Ribble Valley Borough Council  
Housing & Development Control

Application number: **2020.0955.FULL**

Address: **The Owls, Wigglesworth Road, Tosside, Skipton.**

Proposal: **New vehicle entrance to allow parking for two cars, landscaping at rear, boundary wall to replace with a gate and new boundary wall constructed.**

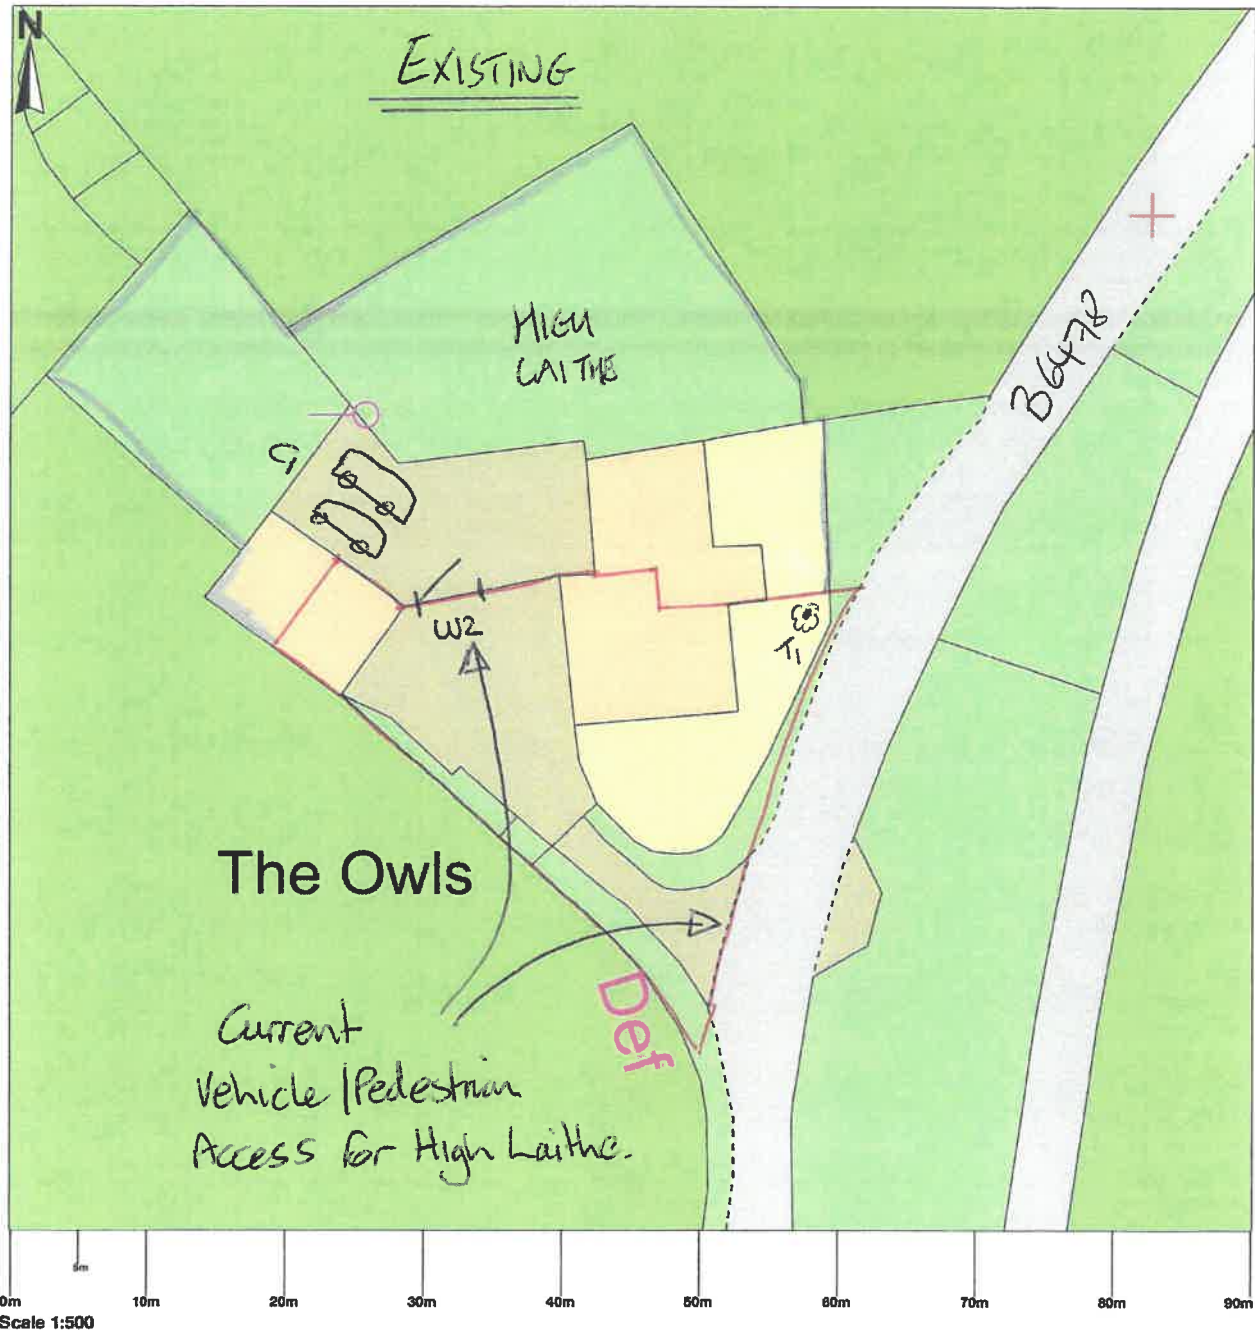
It should be emphasised that the access track lies beyond the limits of the adjacent adopted highway – managed and maintained by a third party and shown via a submitted location plan to lie outside of the control of the applicant and designated by a blue line boundary.

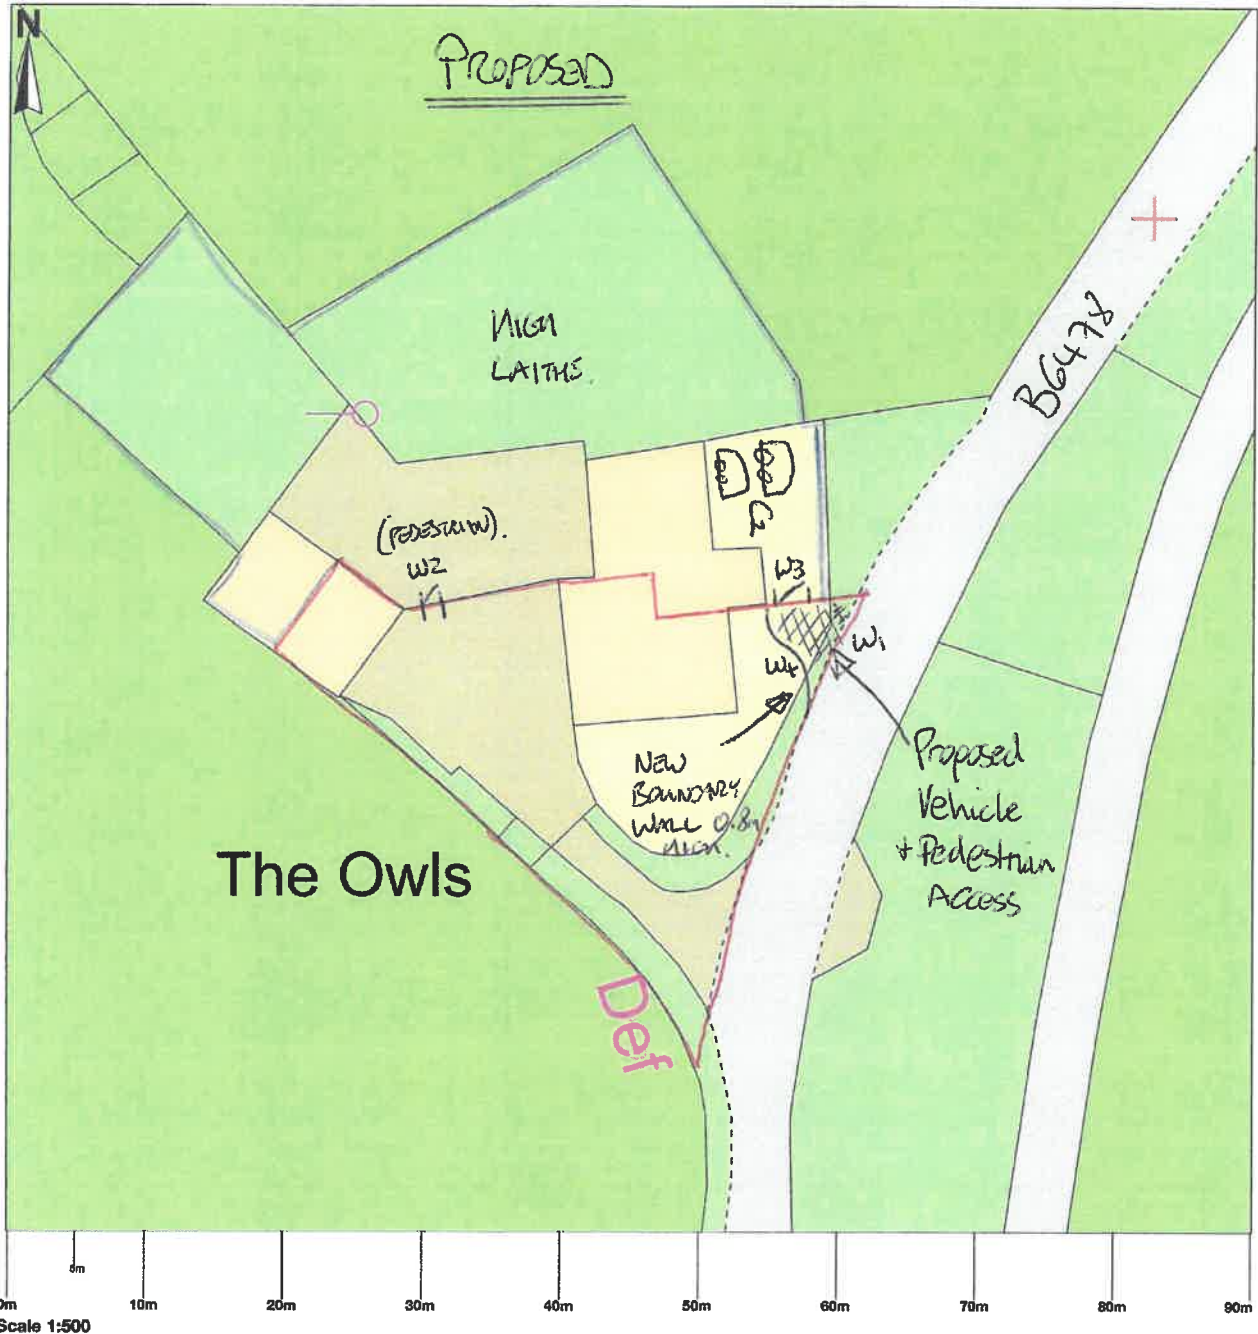
- The submission of a proposed schematic plan indicates construction of an area of hardstanding with parking provision for two vehicles. There would appear to be little if any provision for the turning of vehicles within curtilage there by facilitating access / egress from the site using a vehicles forward gear.
